**KIRKLEES METROPOLITAN COUNCIL
INVESTMENT & REGENERATION SERVICE**

DELEGATED DECISION TO DETERMINE PLANNING APPLICATIONS

Reference No:	2024/62/92848/W
Site Address:	Marsh Carpets, 82-84, Westbourne Road, Marsh, Huddersfield, HD1 4LF
Description:	Alterations to convert first floor to 2 dwellings; sub-division of one ground floor retail unit to two retail units (use class Ea); installation of new shop fronts to south and east elevations and construction of external staircase to northern elevation including associated works
Recommending Officer:	Emma Thompson

Officer Report

Drawing
Proposed Floor Plans

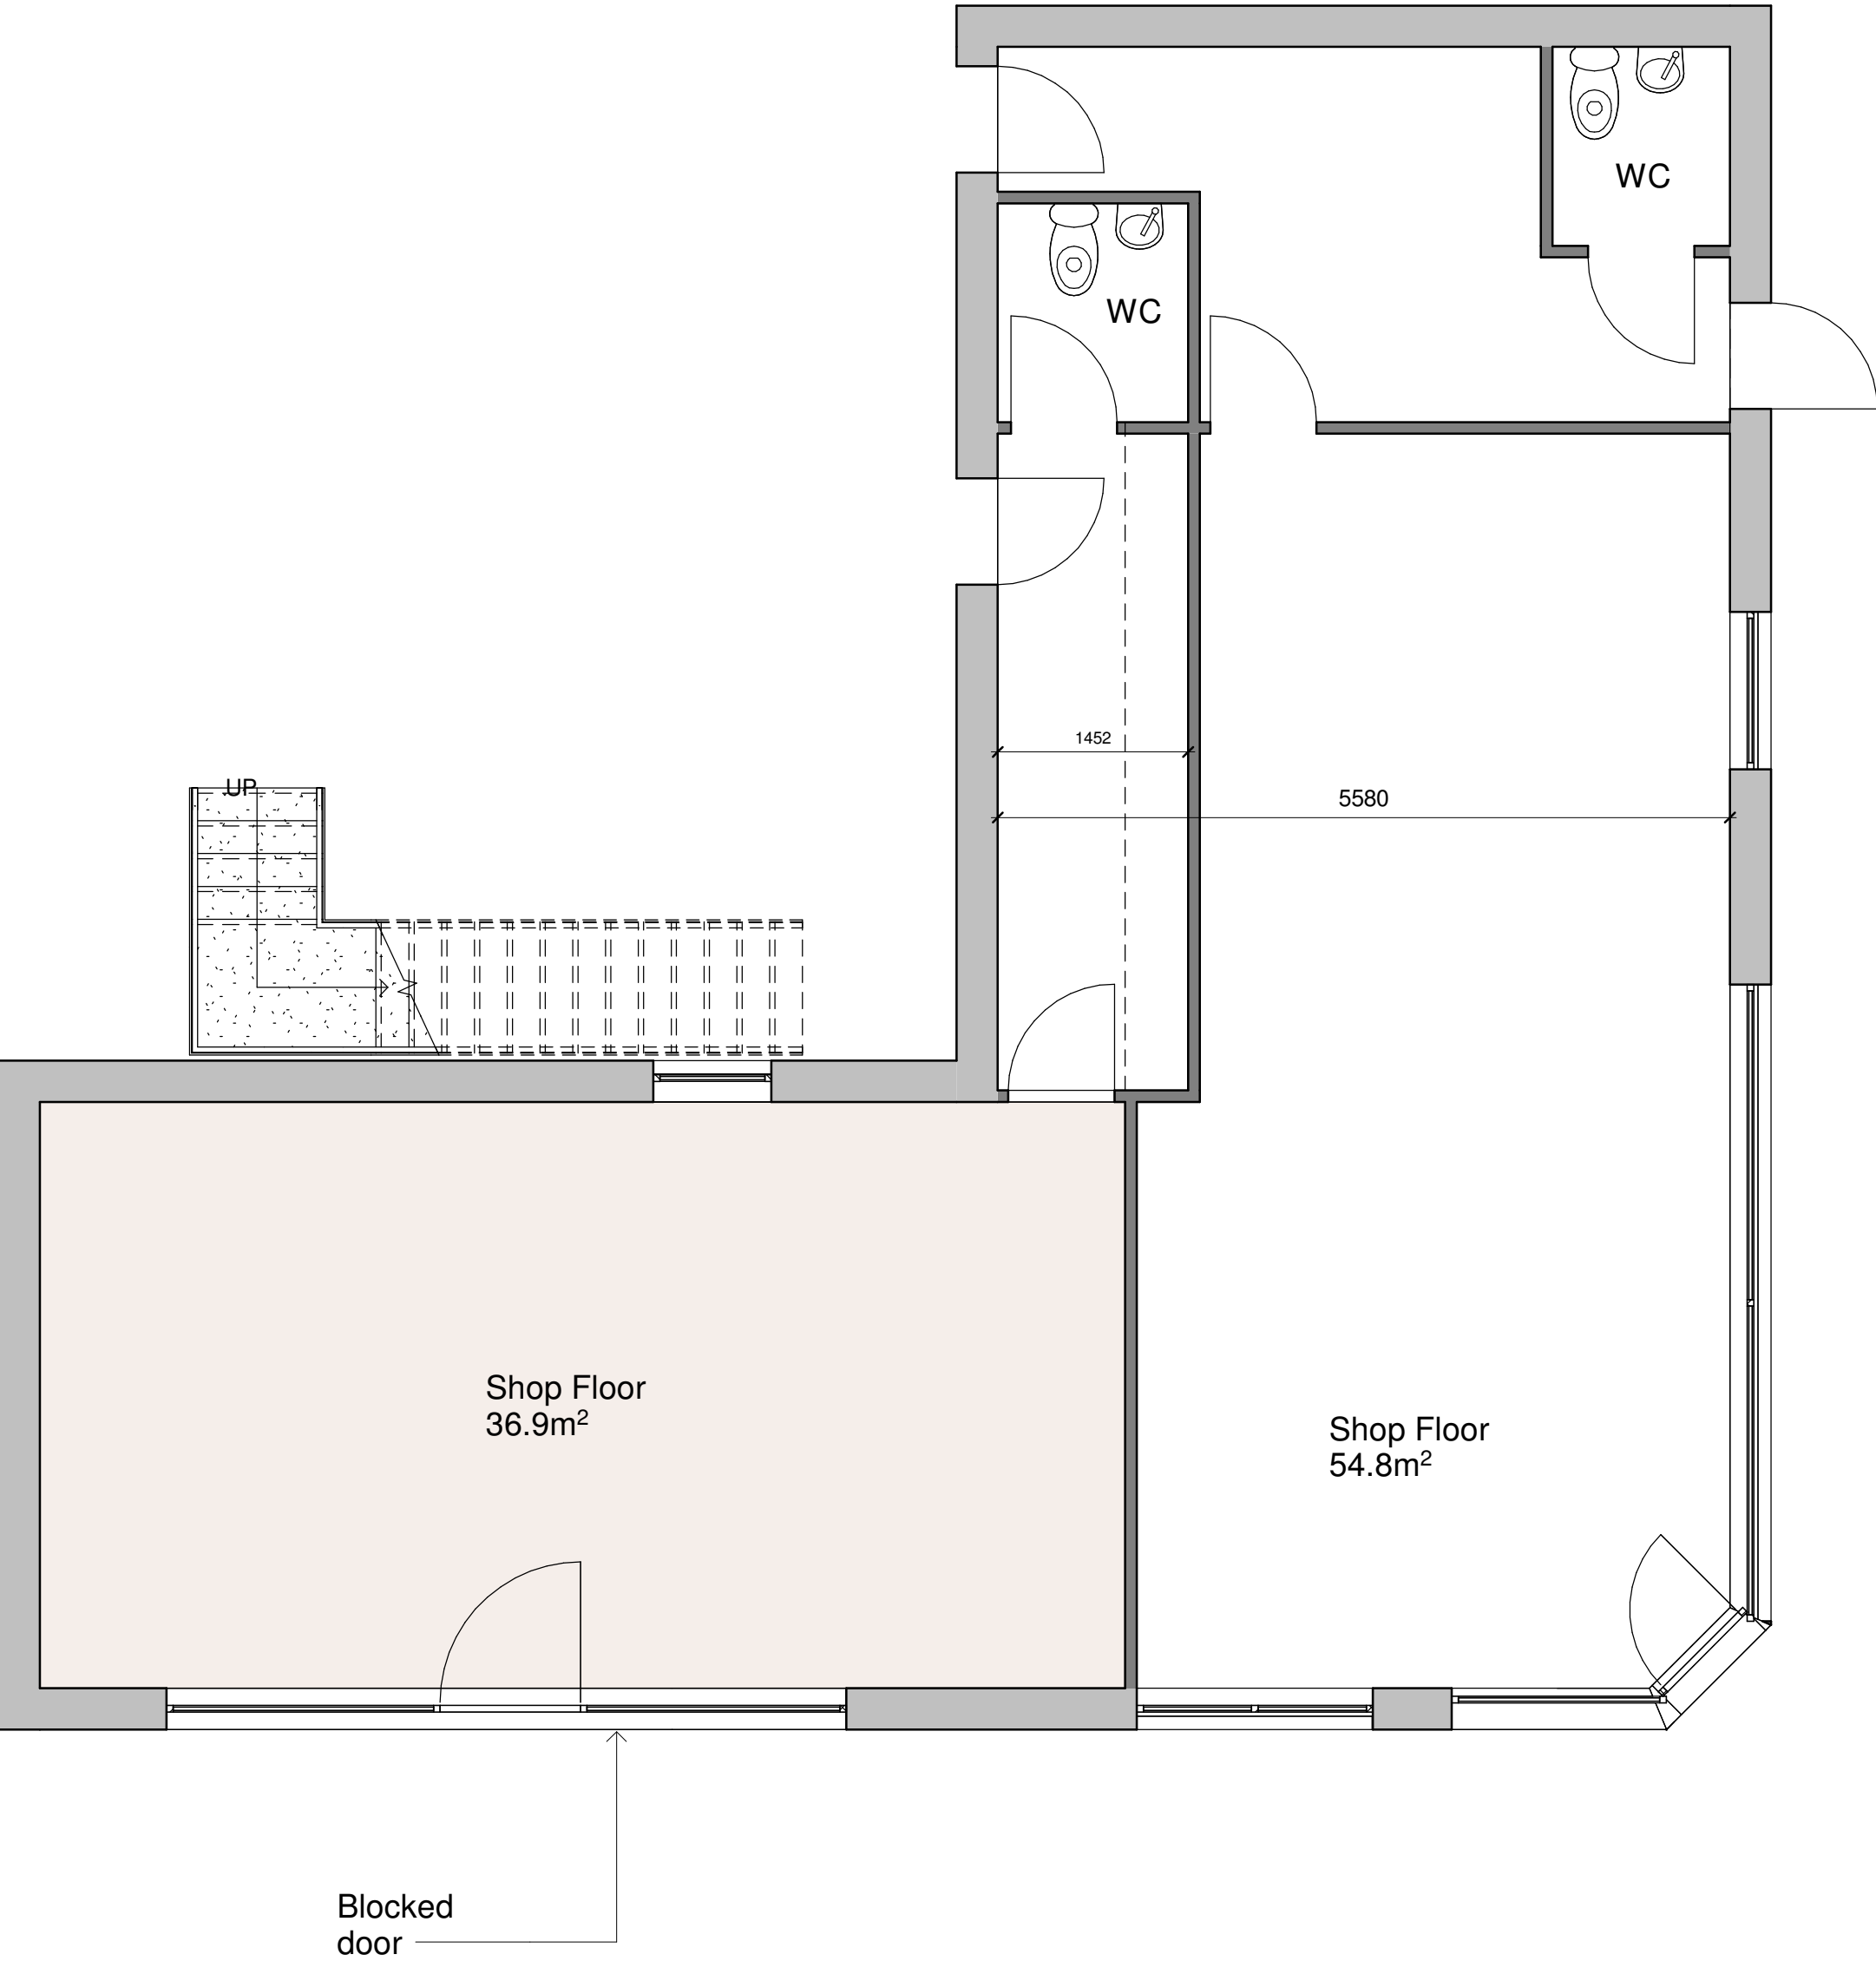
Flat 1 is shown to occupy an area of about 90sqm. It offers accommodation over two floors and could be described as being ‘two storey’ for the purpose of space, however it remains a flat within a block and as such a reasonable and pragmatic assessment has been undertaken in respect of space and applying the recommended standards. A kitchen, living, dining on the first floor and bedroom plus study constructed into the roof space. The bedroom is of a size to provide adequate amenity for future occupants. The study room is large enough to provide bedroom space and would not appear cramped in the unit. Concerns regarding outlook have been addressed by the provision of a section through the unit. It is considered, on balance, that an acceptable living standard can be achieved.

Flat 2 is a smaller unit measuring 57sqm which is located fronting Westbourne Road. This unit has one large bedroom and a room labelled study room and therefore adequate size for a one bedroom 2 person unit. In planning terms, the study room is not classed as a bedroom as the 57sqm is short of the 61 sqm required. The bedroom exceeds the recommended size for a 2 person unit and natural light is provided to all areas. Whilst there is no private amenity space designated for the properties, the location is in reasonably proximity to local parks giving reasonable access to outdoor spaces.
